Appeal Decision

Appeal Ref: APP/Z4718/D/18/3197229

33 Wilshaw Road, Meltham, Holmfirth HD9 4DZ

Drawing title
PROPOSED FLOOR PLANS and EXISTING and PROPOSED SITEPLANS

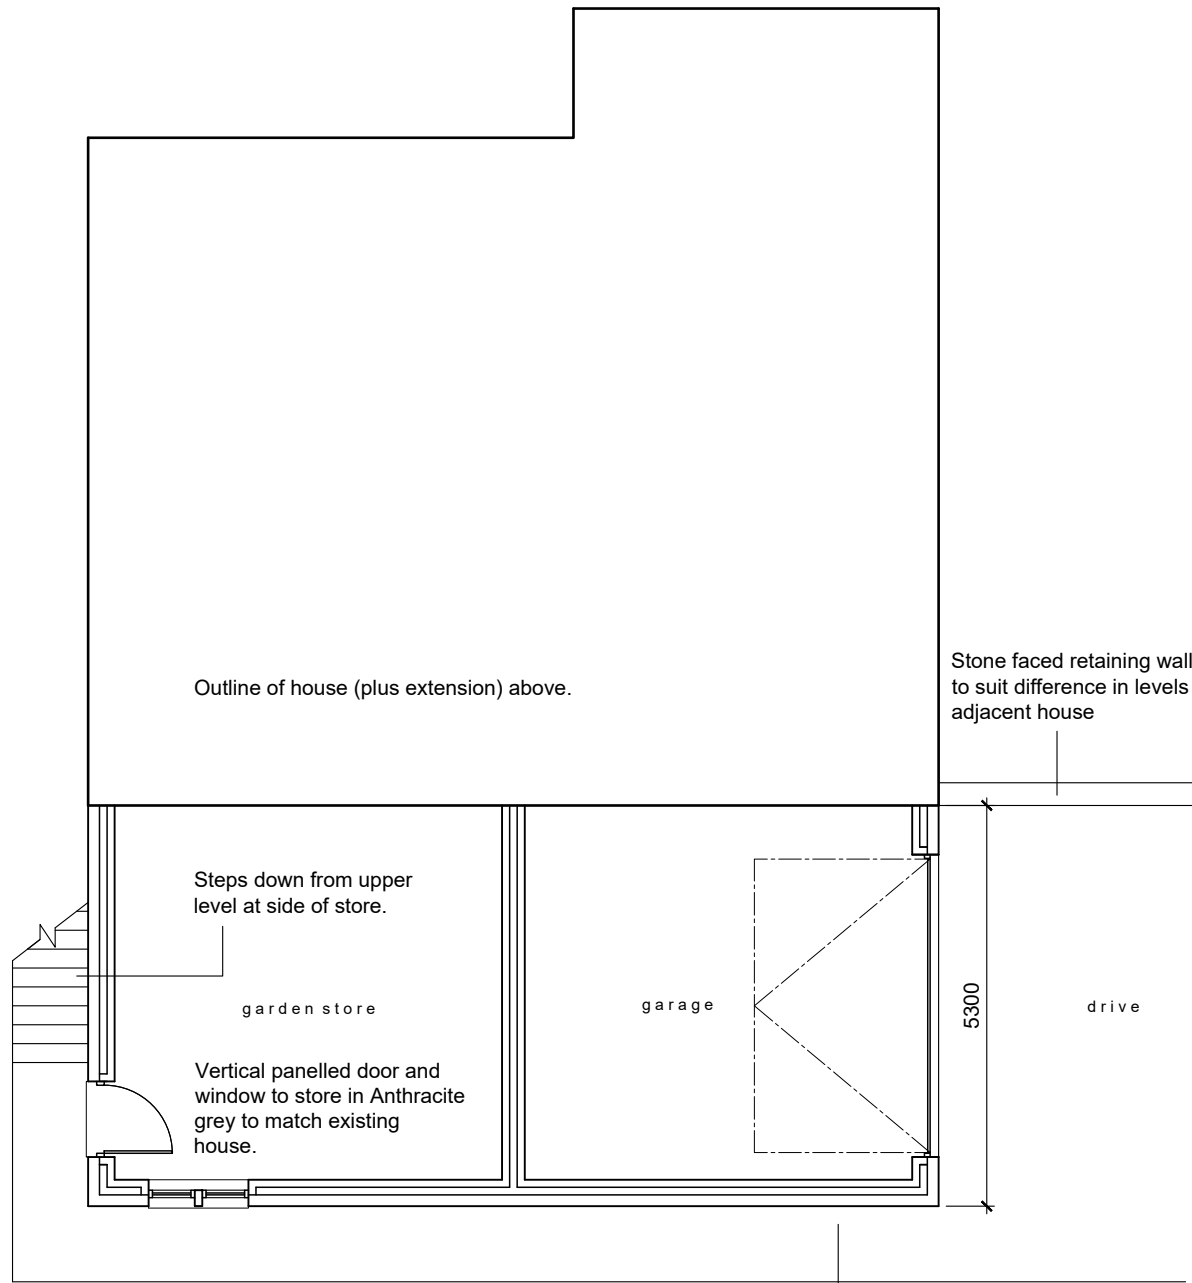
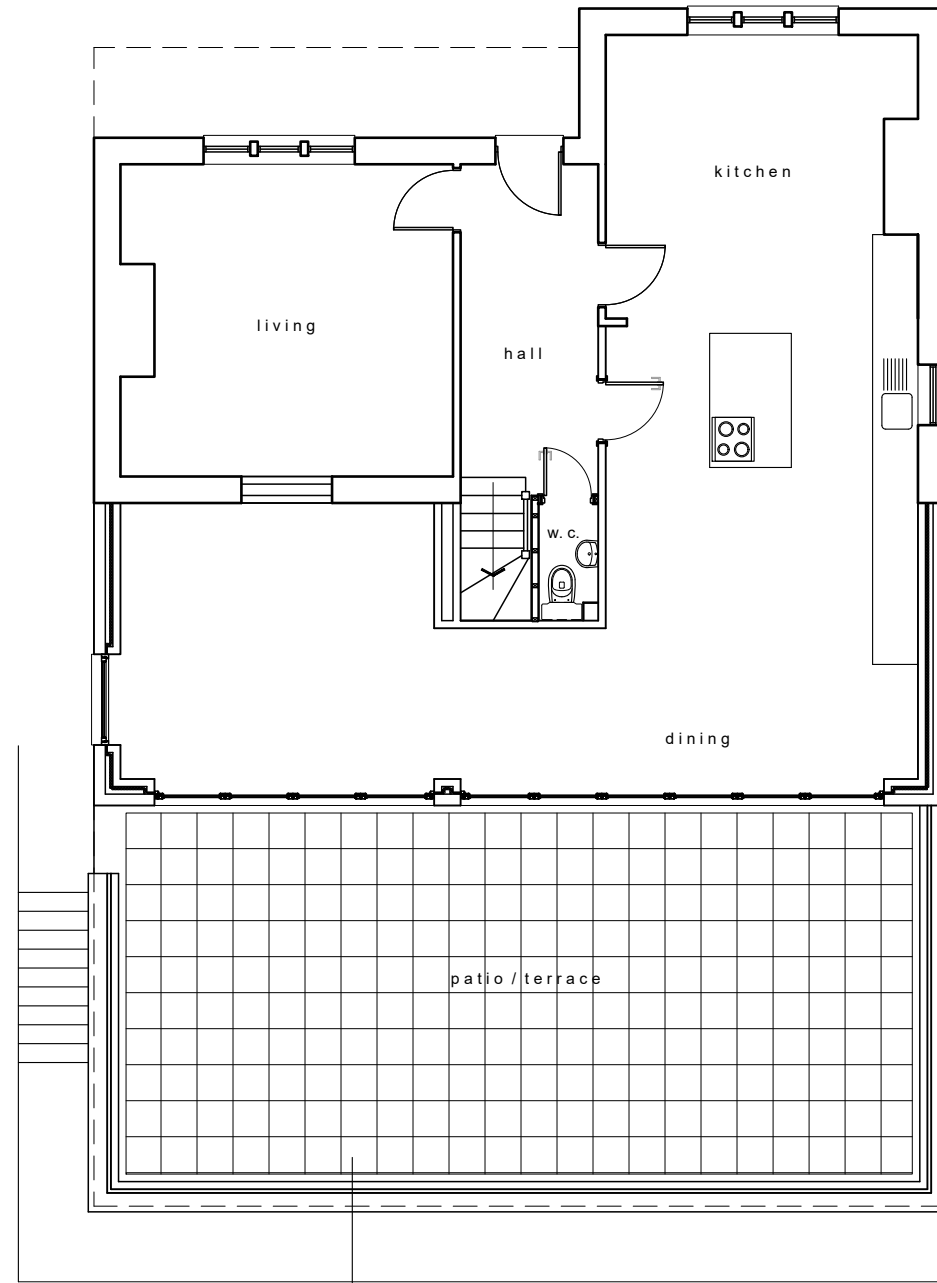
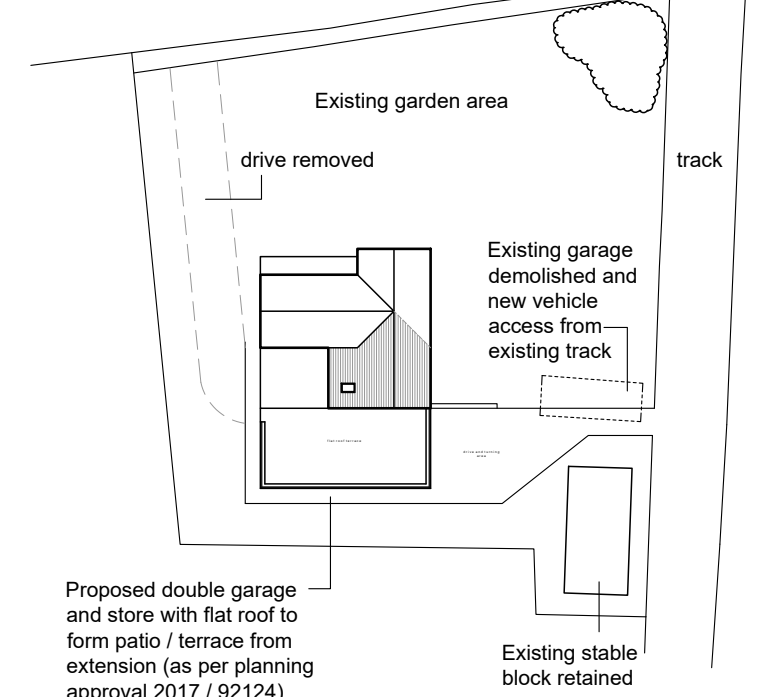
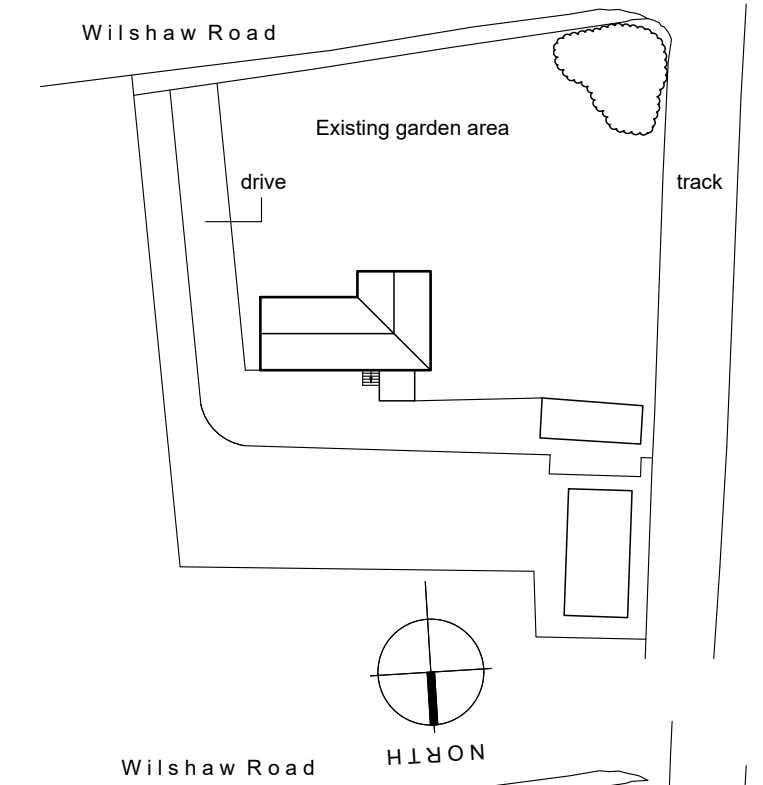
5. Permission¹ was granted in August 2017 for the demolition of the garage and the erection of a two storey and single storey rear extension with first floor balcony and detached garage. The two storey and single extension proposed in the appeal scheme are the same as those previously approved, but it is now proposed to also create an attached garage and garden store room at lower ground level with a terrace above them serving the ground floor of the dwelling.

7. However, even if the previously approved detached garage is not constructed on the site, the appeal scheme would represent a further substantial extension to the rear of the dwelling, with the overall depth of the total extension being significantly greater than the depth of the original house. Whichever calculation is adopted, the appeal scheme would result in a very large increase in the size of the house. I take the view that an increase in the floor area and volume of the original dwelling of the scale proposed cannot be considered to be anything other than disproportionate.

11. The appellant has suggested that when ground levels are reinstated and the area landscaped, there would be limited visibility of the proposal. Nevertheless, significant regrading of the surrounding land would be required to provide external access to the garage and garden store room. Due to the height of the boundary wall to Gill Birks immediately to the west of the site, the extension would be visible from this track, which provides access to a small number of houses, as well as being a public footpath. In any case, a lack of visibility does not, in itself, mean there is no loss of openness.

14. The additional extension proposed would be below the original ground level, and so would potentially be less visible than the detached garage approved in the previous scheme. However, not only is it considerably larger than the approved garage, but as it is attached to the host property, rather than being a detached outbuilding, it would add a mass and bulk to the house that the previous garage would not.

19. The existing property has a drive to the eastern side of the site. This would provide the access to the approved detached garage. However, it is indicated that the width of the drive is not sufficient to allow the turning of vehicles, so it is not possible to enter and exit the site in forward gear. The proposed garage would be accessed from Gill Birks and there would be sufficient space to the front of the garage to enable vehicles to turn. The appellant has argued that this represents an improvement to highway safety.
